**Gosford Hospital Redevelopment (SSD 6913) - Public Exhibition**

## **Attachment 1 – Detailed comments on the Traffic and Accessibility Assessment Report for the Gosford Hospital Redevelopment**

Sheet Subject
TURNING PATH PLAN
SHEET 1 - BARIATRIC
AMBULANCE

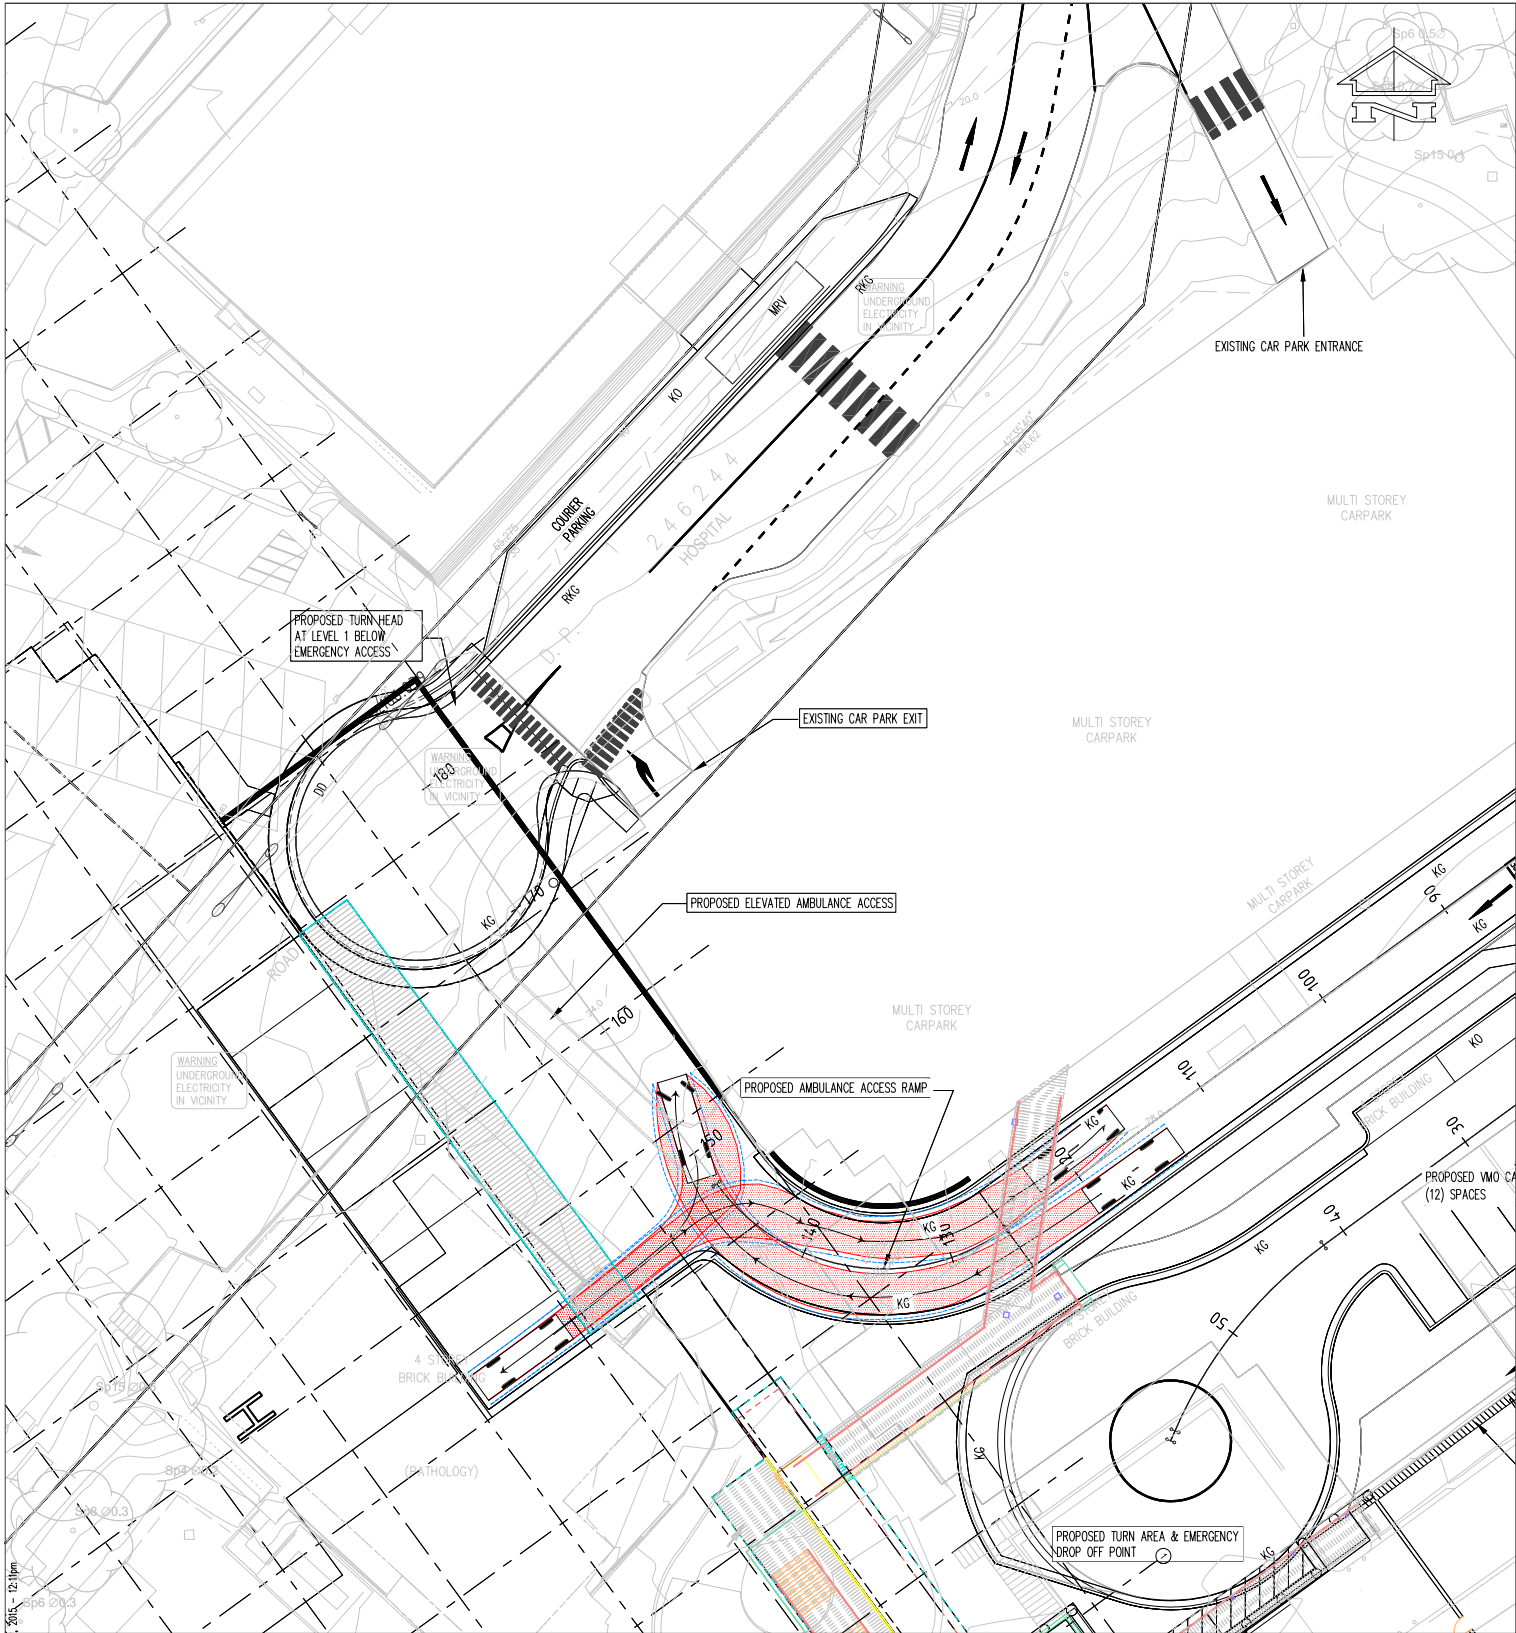
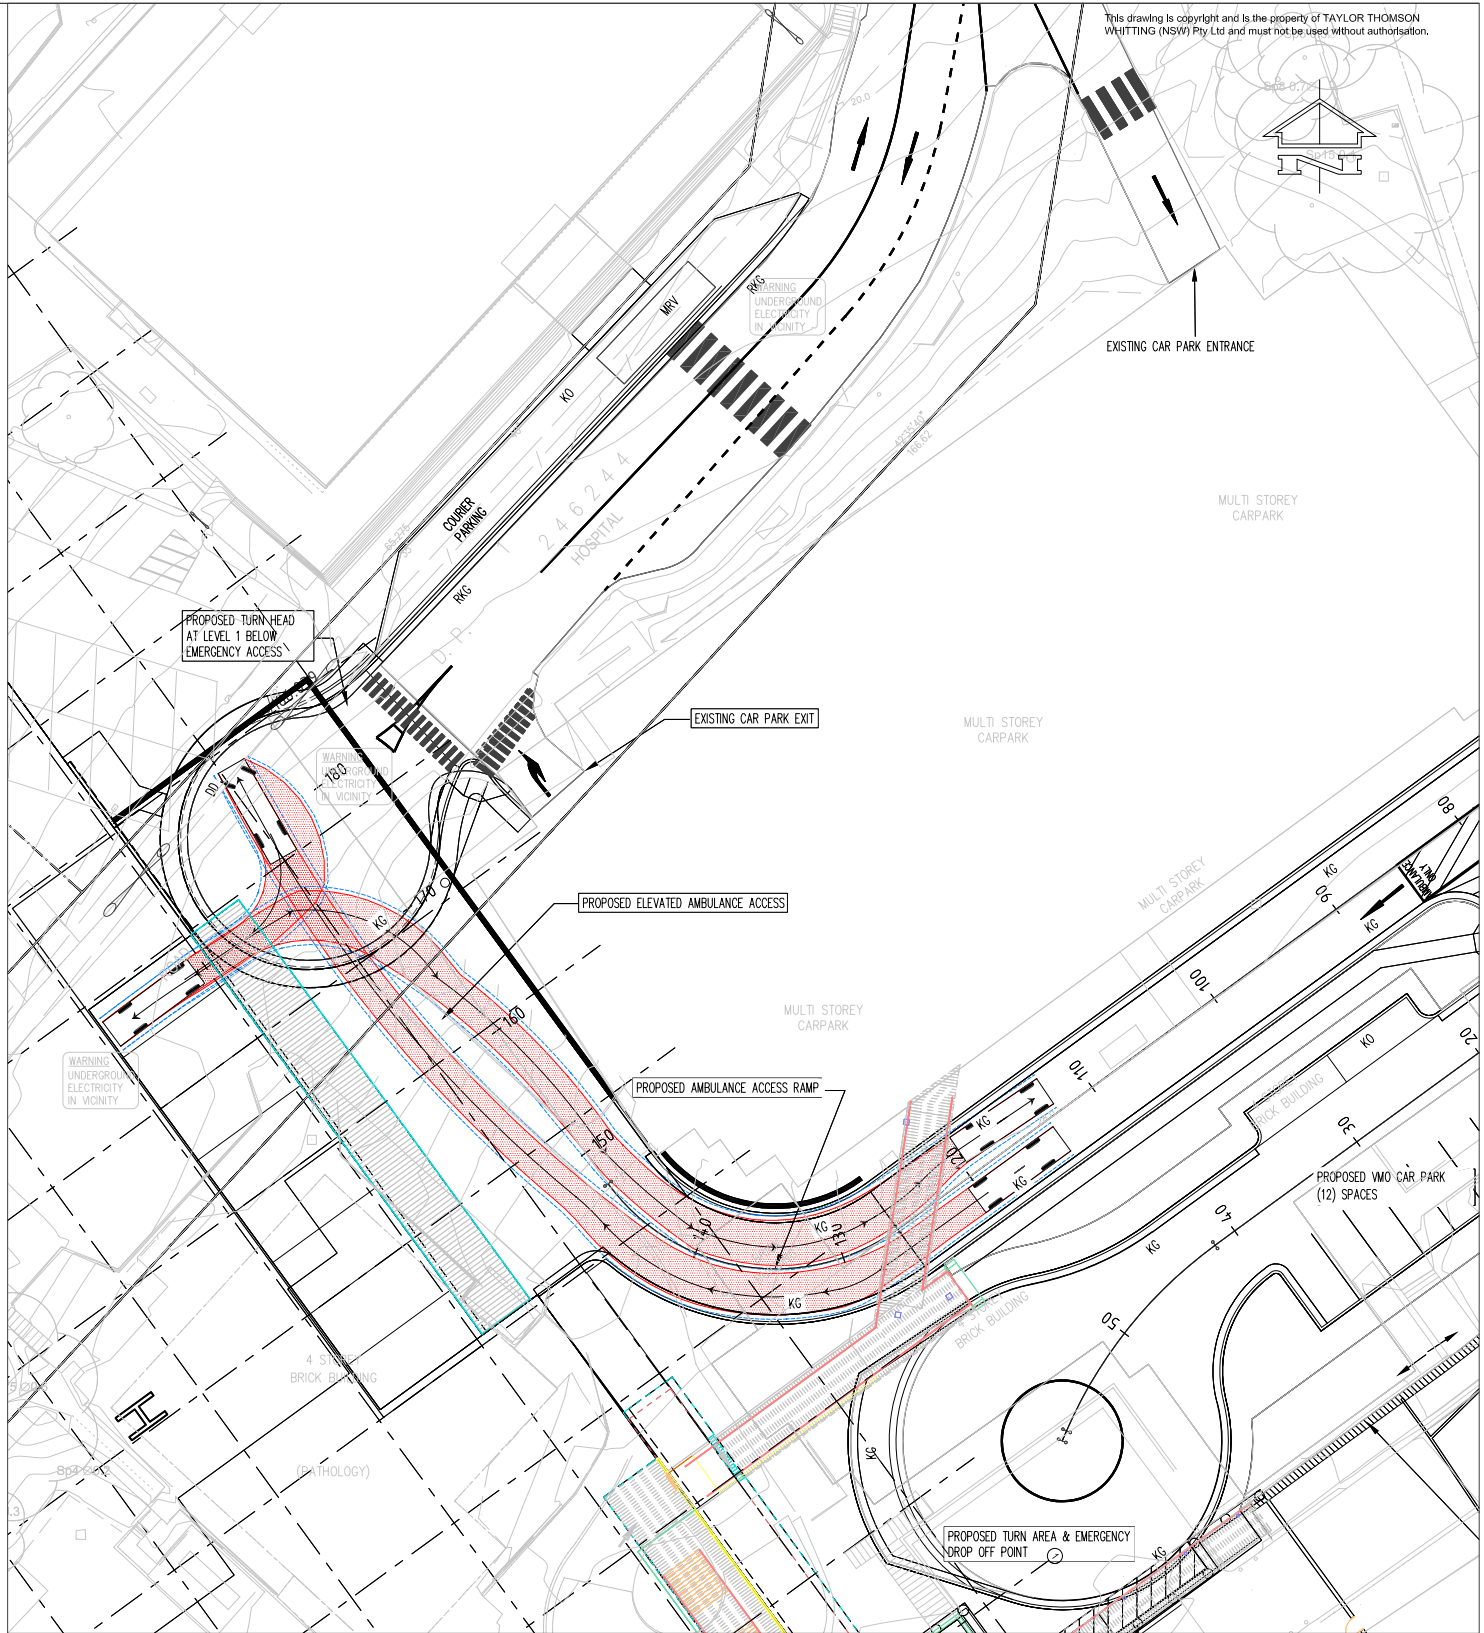
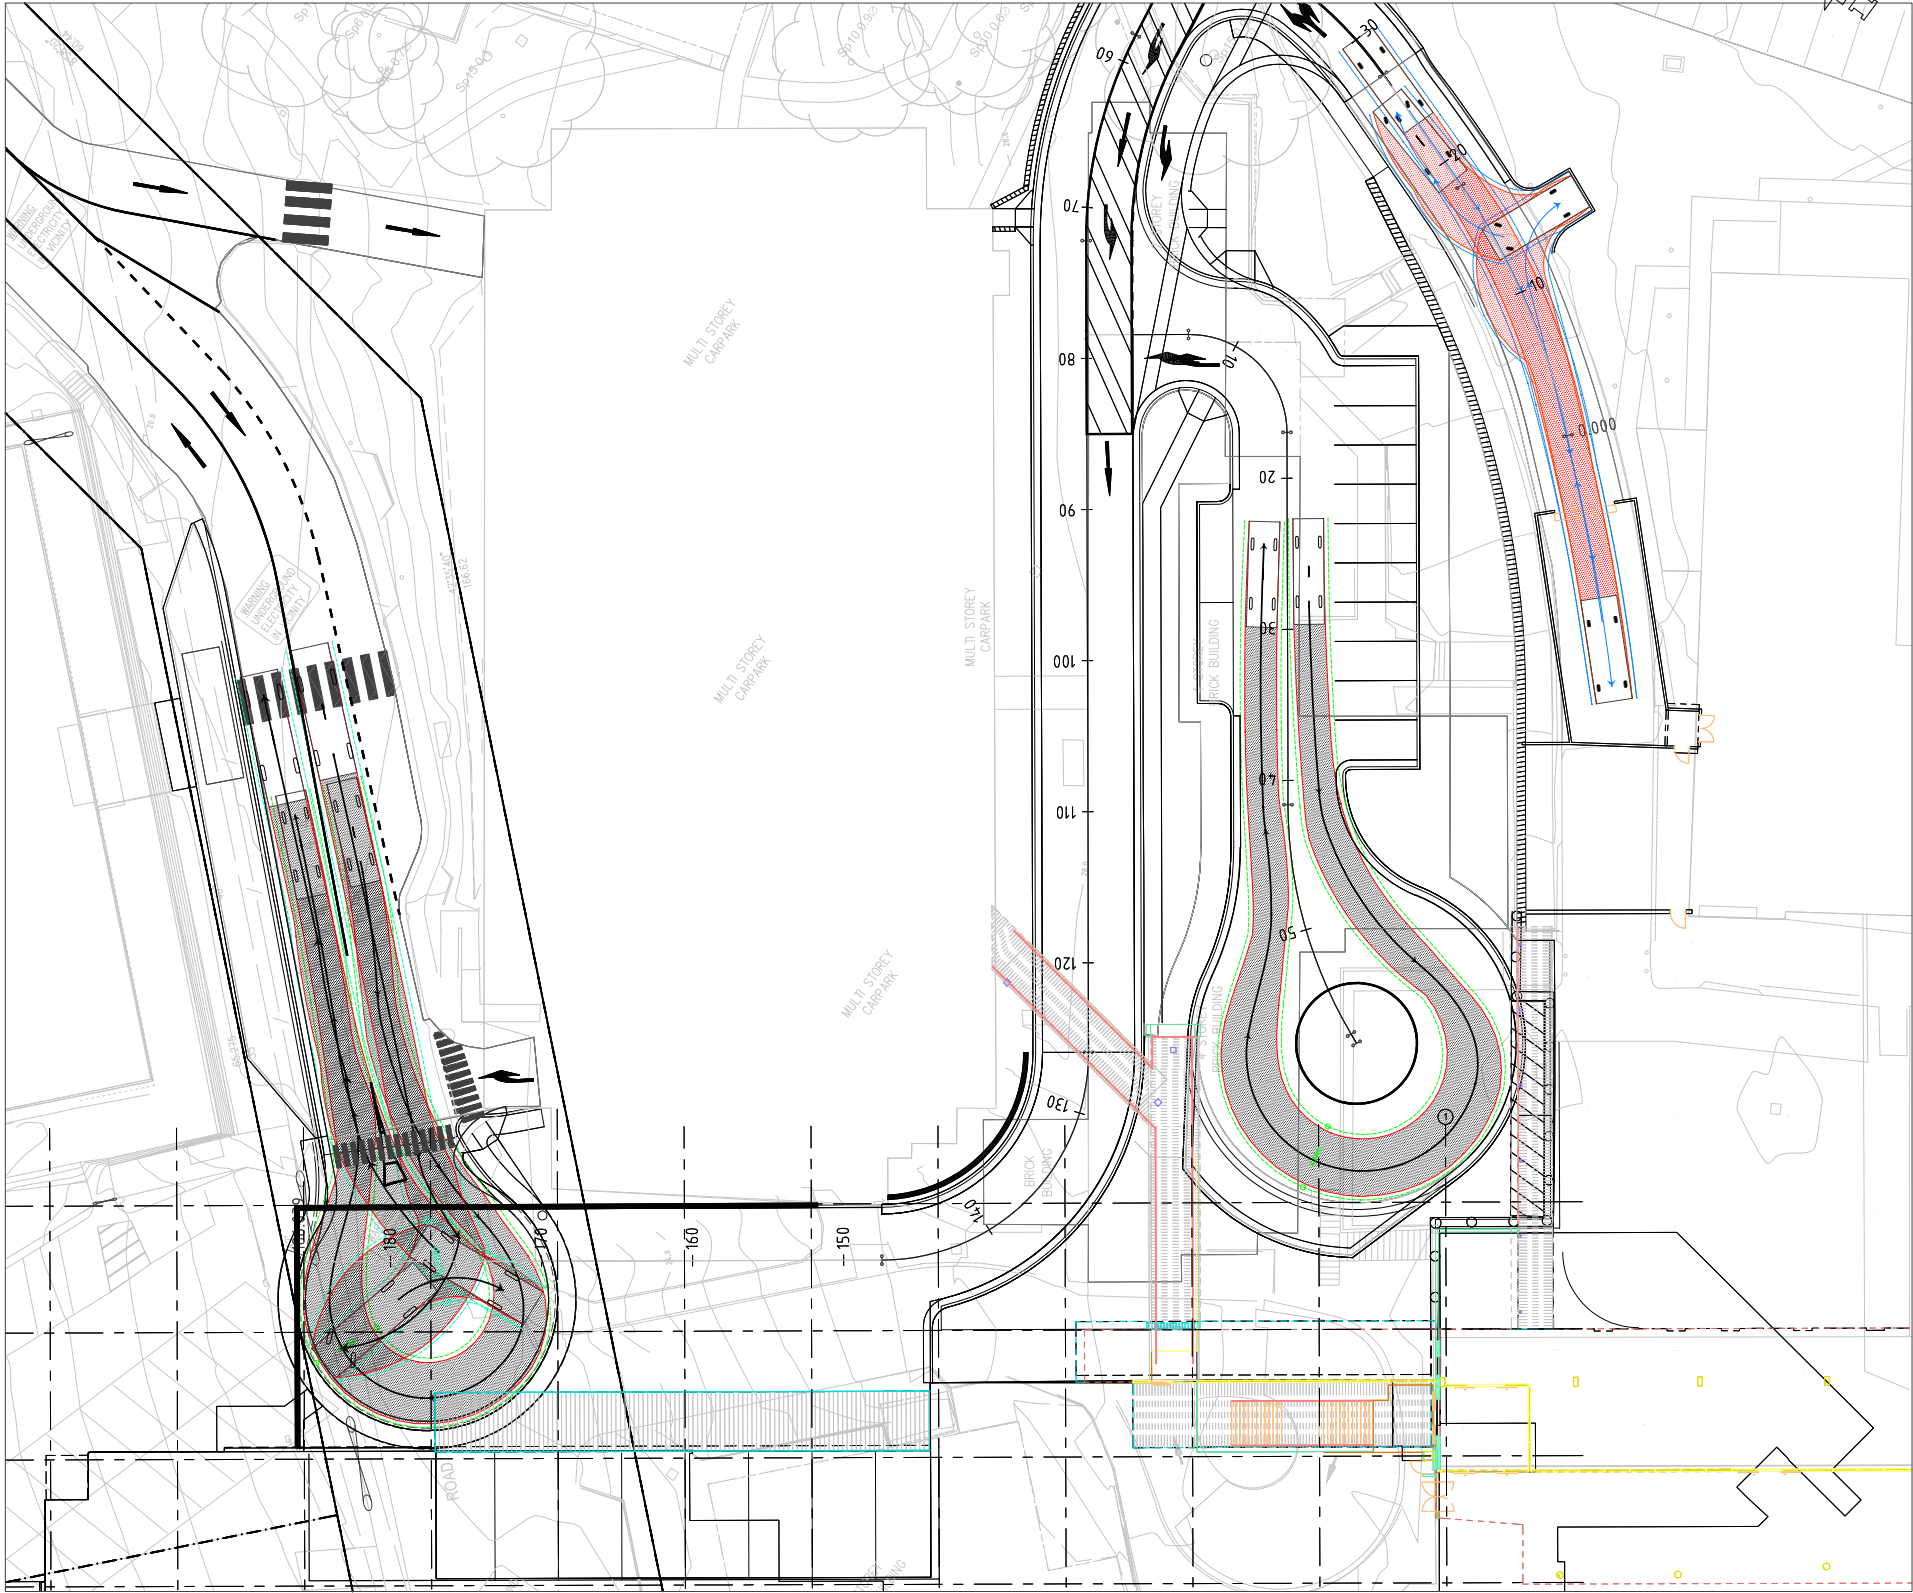
The proposed traffic management works along Showground Road would have the potential to impact on the heavy vehicle movements to and from Sydney Trains depot.

It is requested that the applicant undertakes a detailed swept path analysis to confirm that traffic management works would not have an impact on the heavy vehicle movements to and from Sydney Trains depot.
